Summary of Comments on Microsoft Word - Response to Comments Memo-Abert.docx

Abert Ranch (LSC #164890)

Figure 9  
Year 2040 Total Traffic, Lane  
Geometry, Traffic Control & Level of Service  
Abert Ranch (LSC #164890)

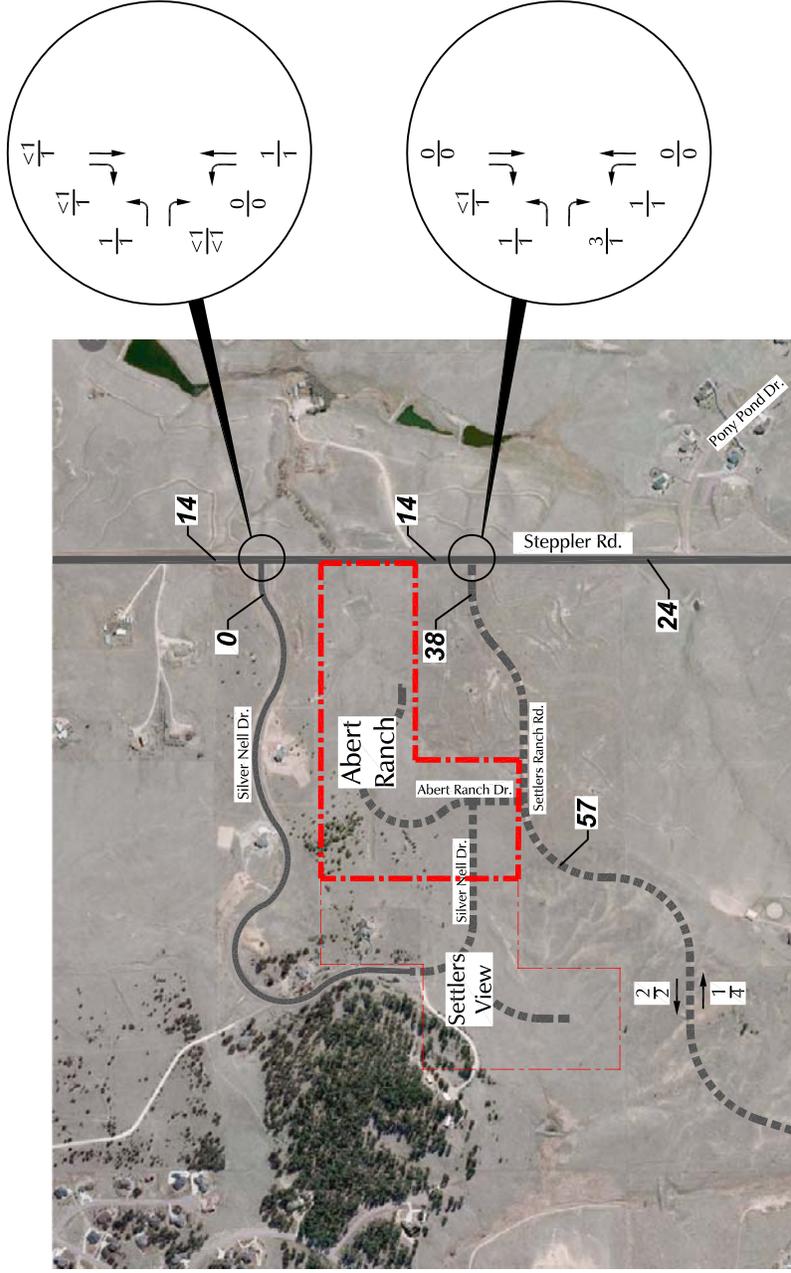
Add the ADT for Steppler Rd north of Silver Nell Dr. on Fig 3, 7, 8 and 9.

Author: jchodsdon Subject: Sticky Note Date: 2/25/2019 1:47:53 PM
LSC RESPONSE: Added to the updated report as requested.
